**WEST SUSSEX COUNTY COUNCIL
INFRASTRUCTURE CONSULTATION**

SUBJECT: EP/123/10

Crinnis House, Seafield Road, East Preston

Outline application for new dwelling

C		
B		
A		
Client	C. DENCH ESQ.	
Address	Crinnis House : SEAFIELD ROAD EAST PRESTON	
Drawing	PLANS	No. 2810:2
Scale	1:100 1:500 1:1250	Drawn <i>B</i> Date <i>Nov '10</i>

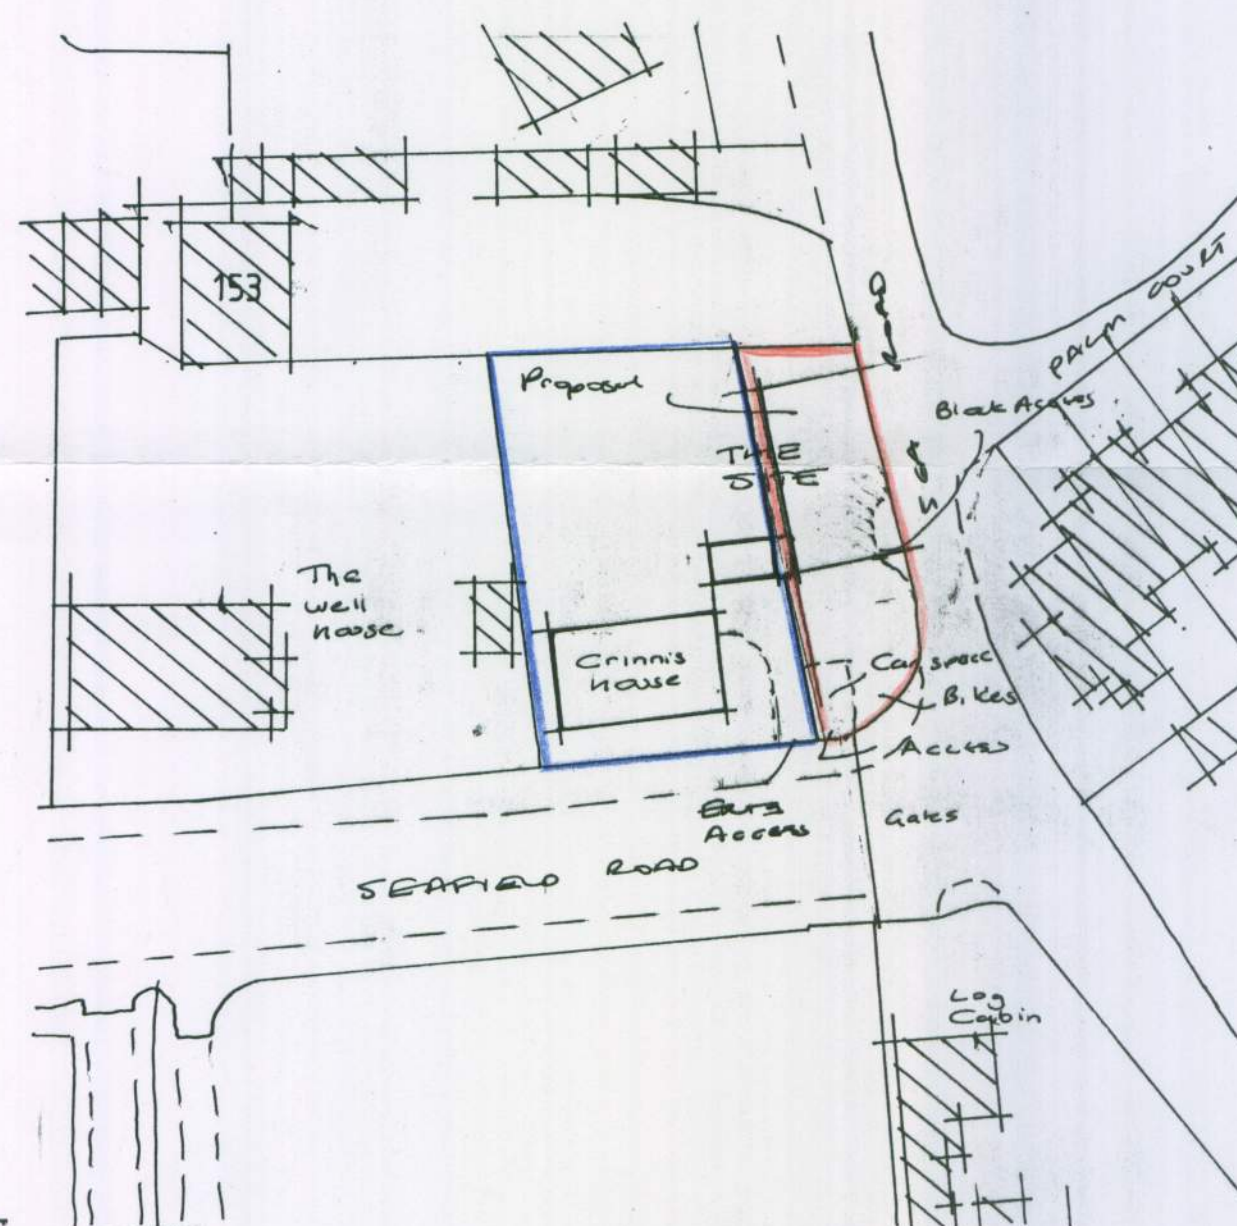
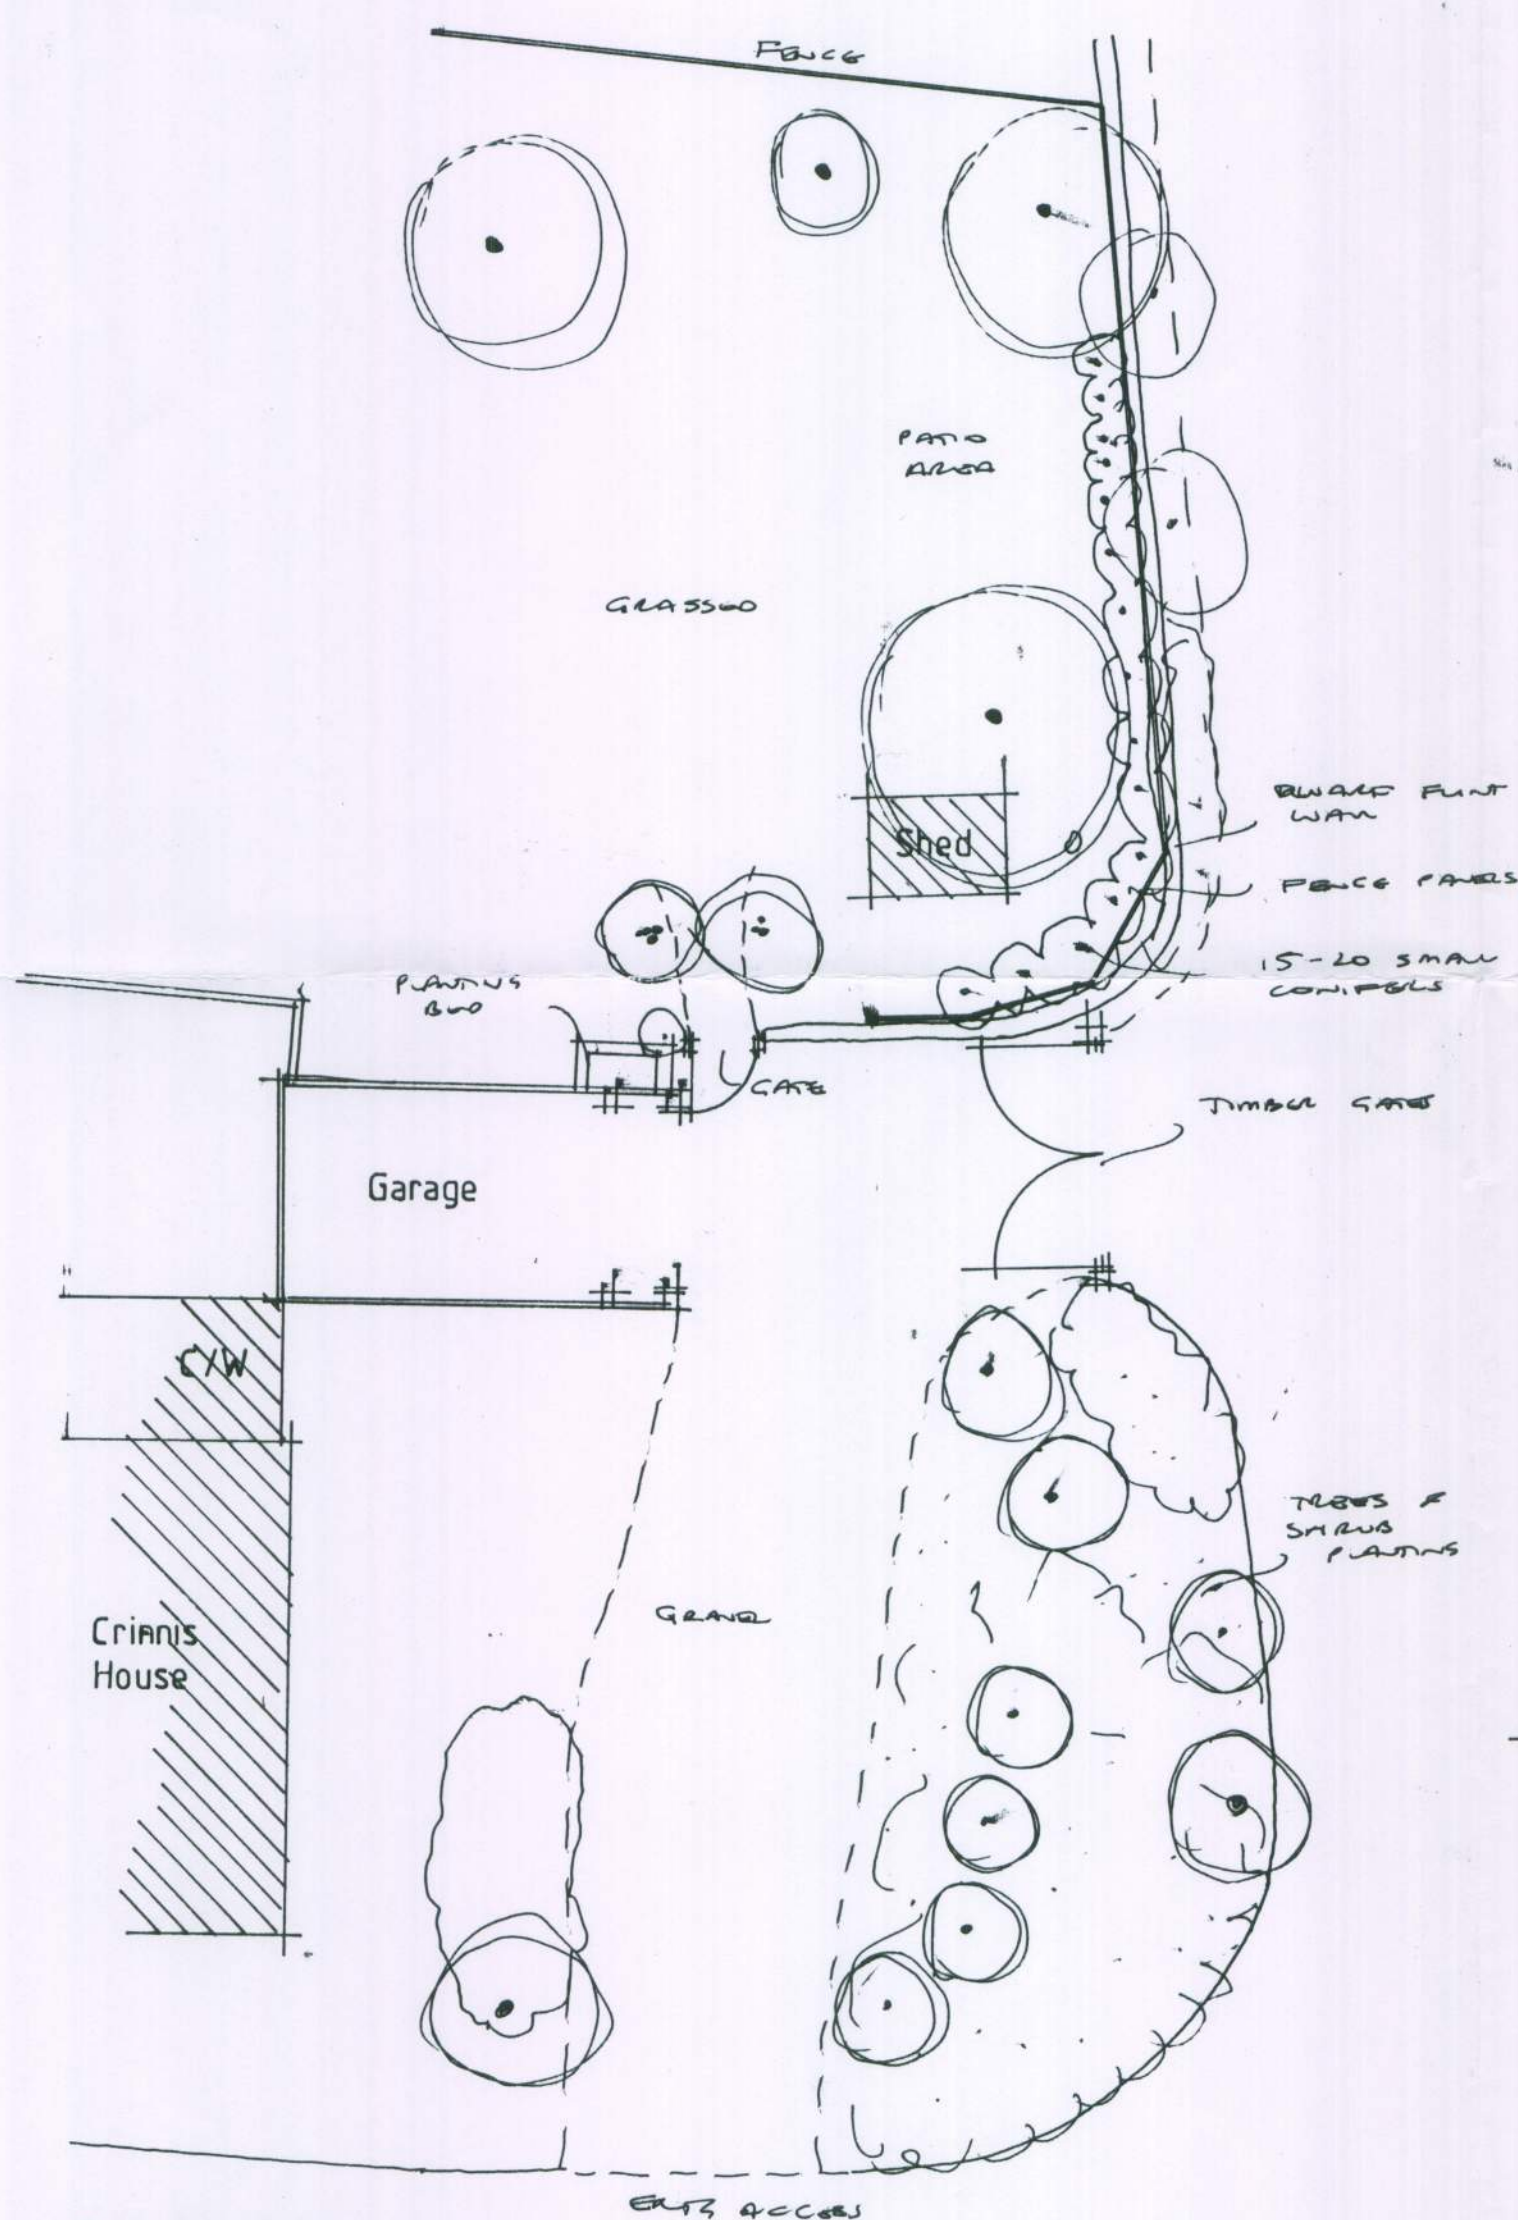
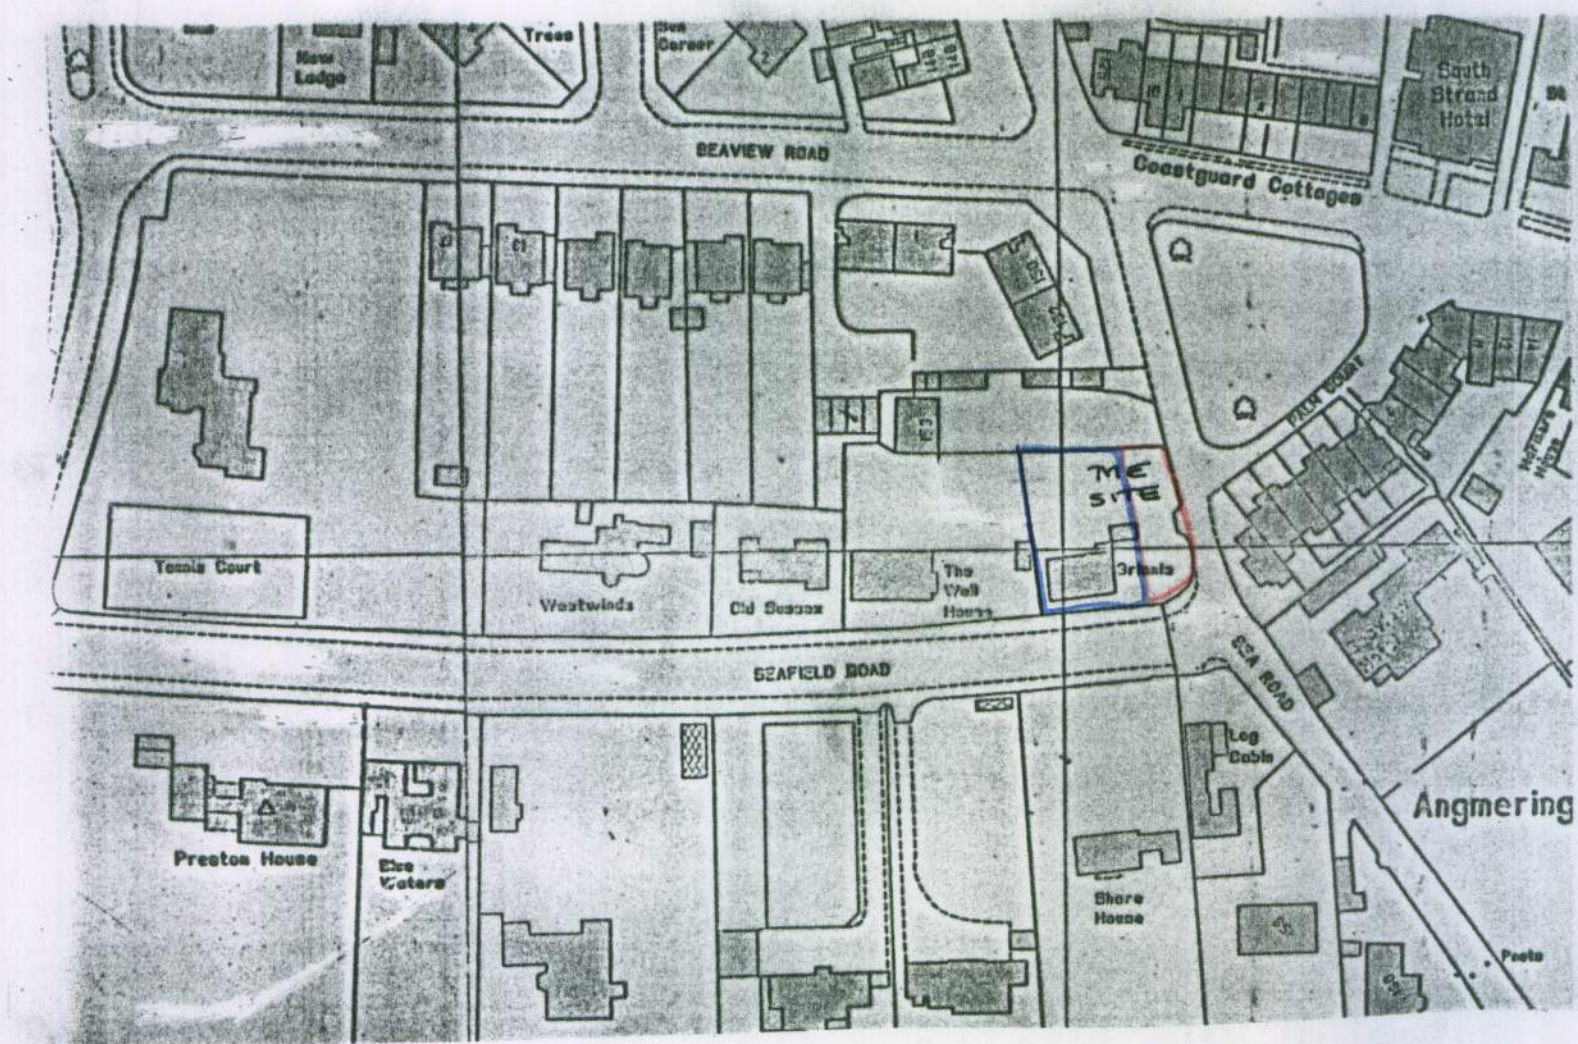
A new access in this location, close to the junction, would potentially impact on highway safety, and therefore WSCC would recommend that the plans be **modified** to provide a shared 4.5m crossover for the new dwelling and Crinnis House.

WSCC has no objections to the principle of the application, providing that the Applicant modifies the proposal to include a shared access rather than constructing a new access. Furthermore, WSCC would recommend that the following conditions be attached to if the LPA are minded to grant this application planning permission:
